**ADC Planning Consultation
Response from the Conservation Officer**

Application Number	AW/267/15/HH
Address	68 The Drive Aldwick PO21 4DS
Description	Minor Amendments to previously approved application AW/344/14/HH for extensions & alterations - This application affects the character and appearance of the Craigweil House Conservation Area.
Case Officer	Mr. D Easton

PROPOSED NORTH ELEVATION 1:100

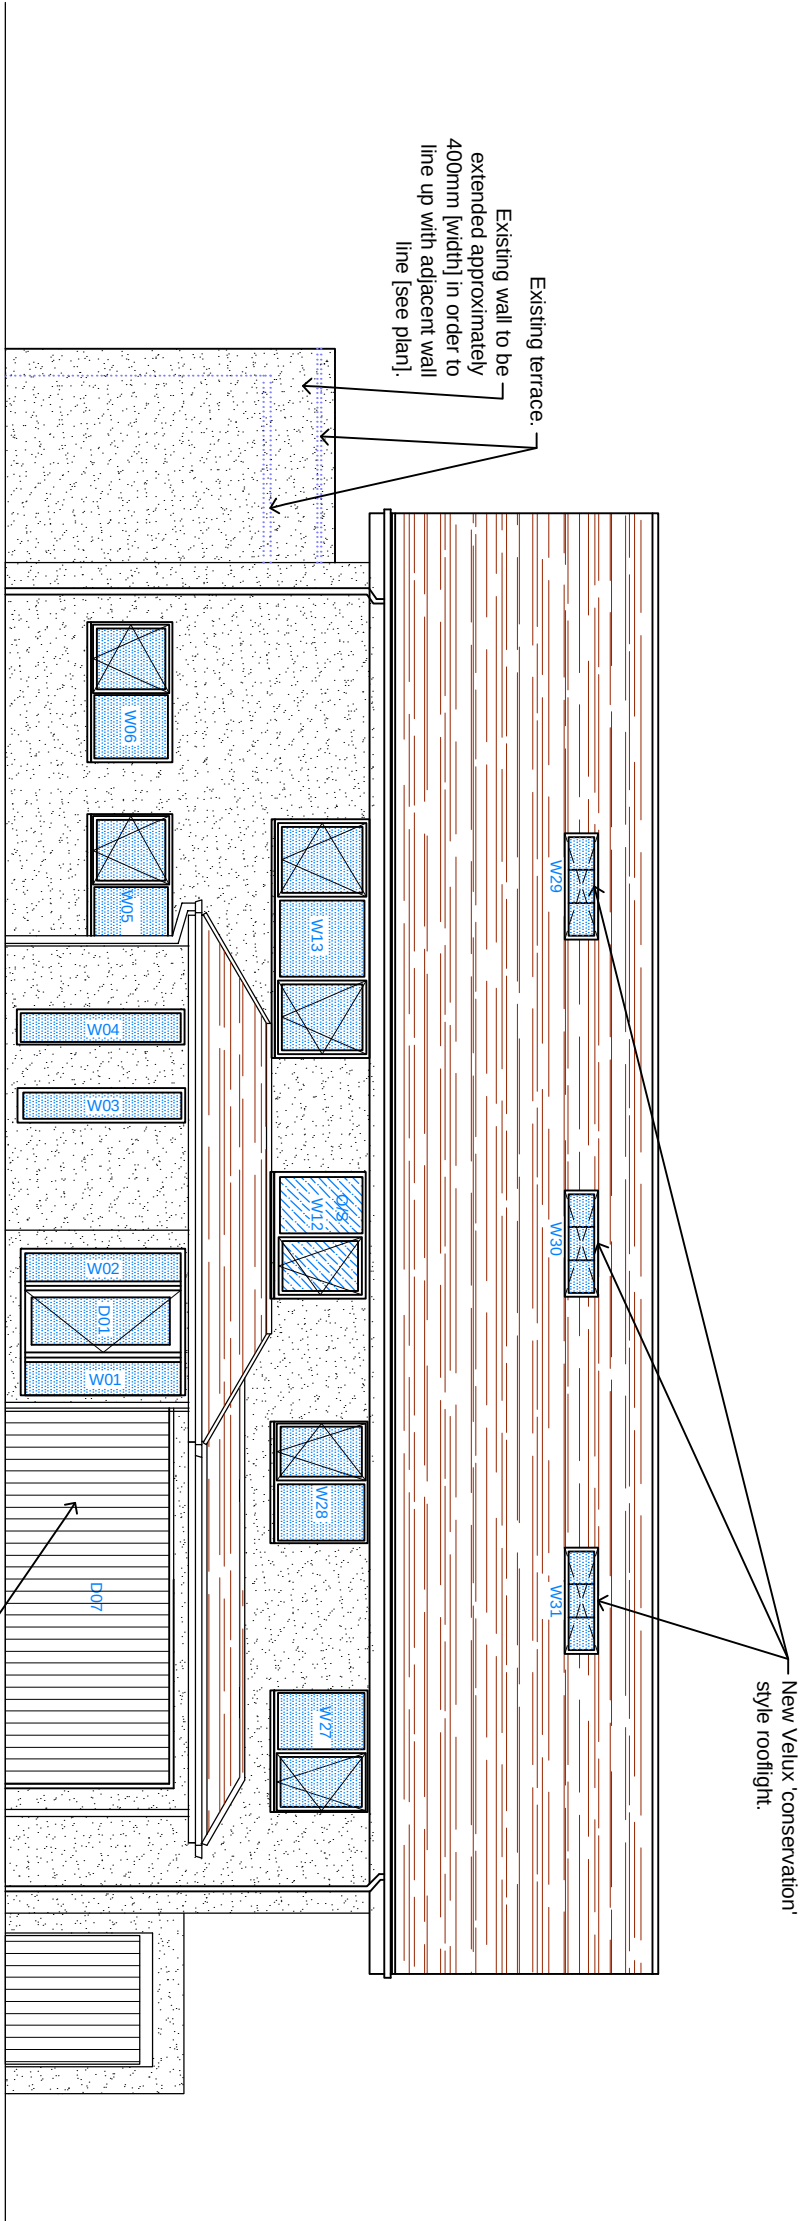
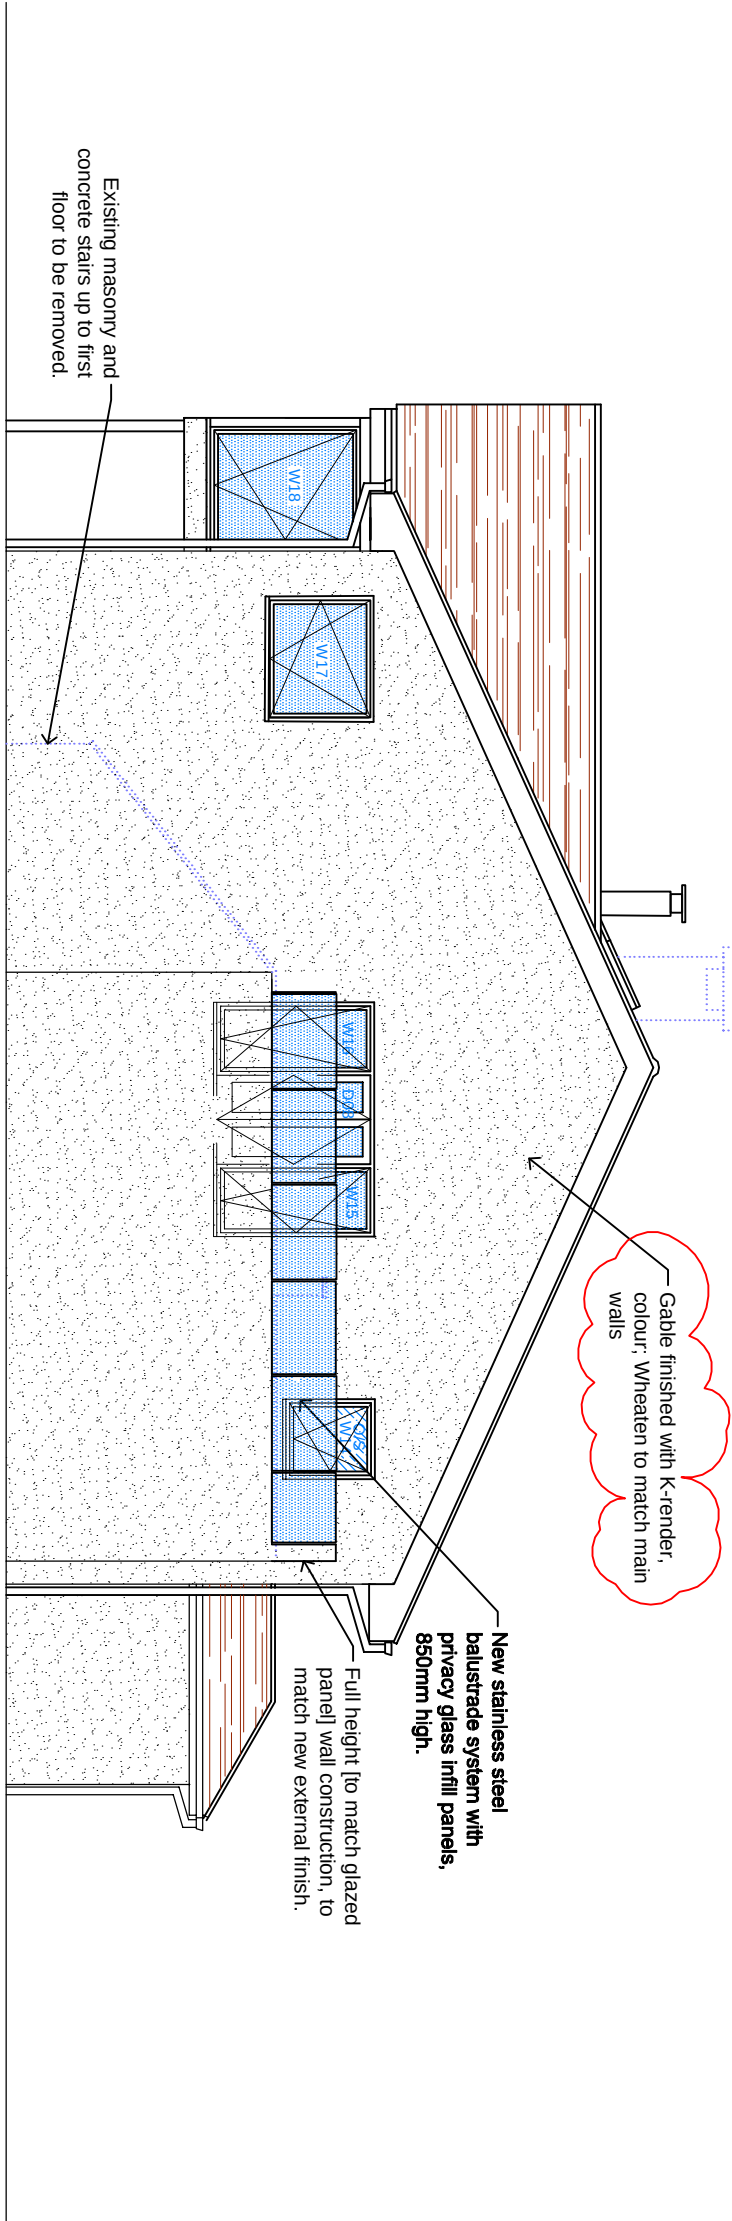
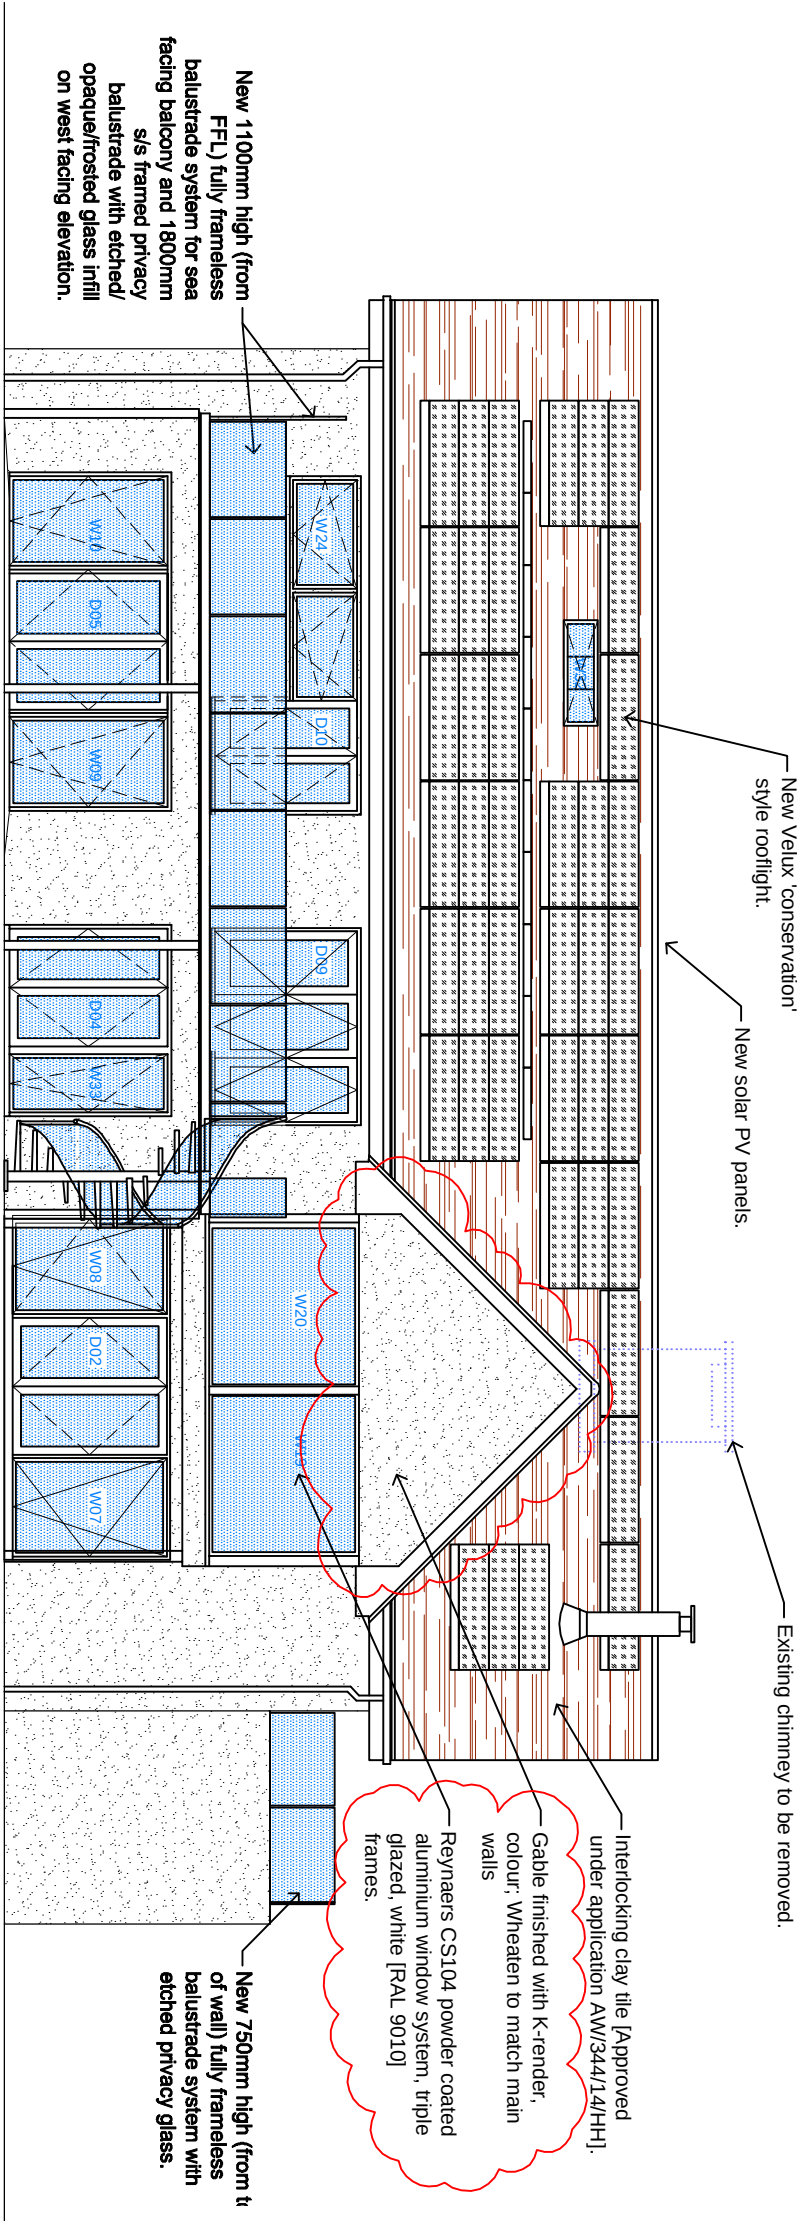
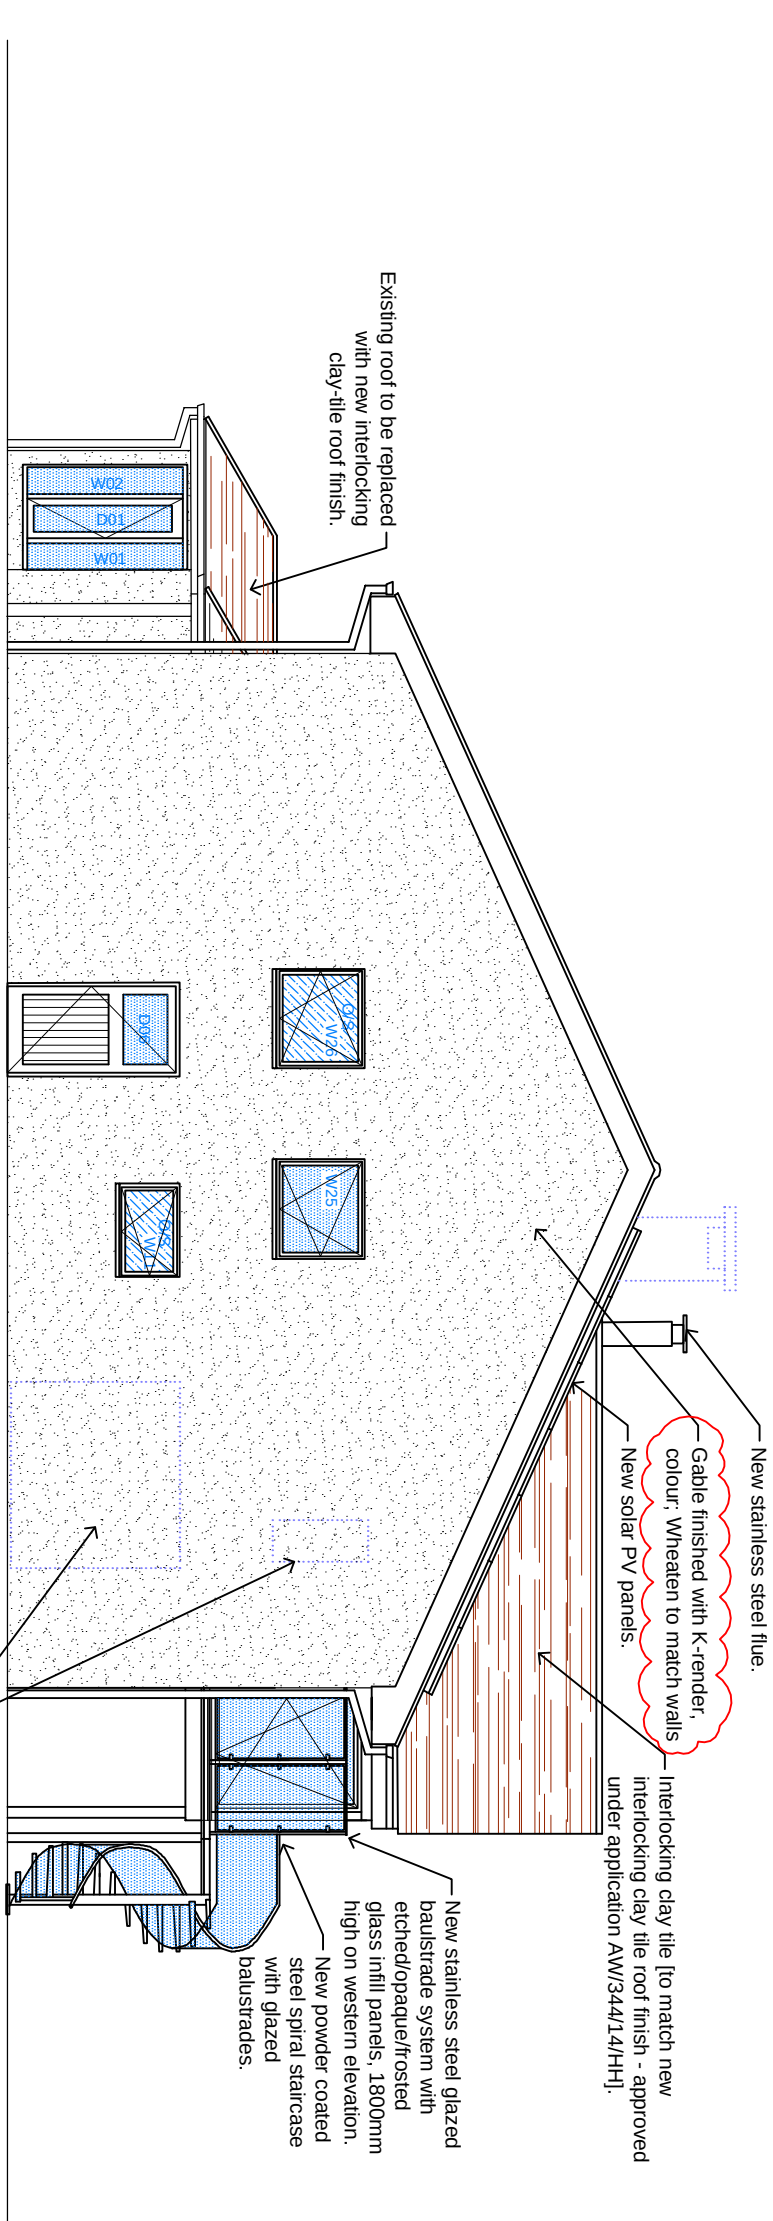
These comments refer to the revised plans. The removal of the grey windows, downlights and weatherboarding is supported.

It is noted that the height of the roof is to be increased by exactly 22cm. The applicant has not made it clear if this increase in height will impact upon the neighbouring properties. It is considered that such an increase in height is unlikely to be overtly detrimental to the property or the local area.

The use of a cream coloured render is considered acceptable.
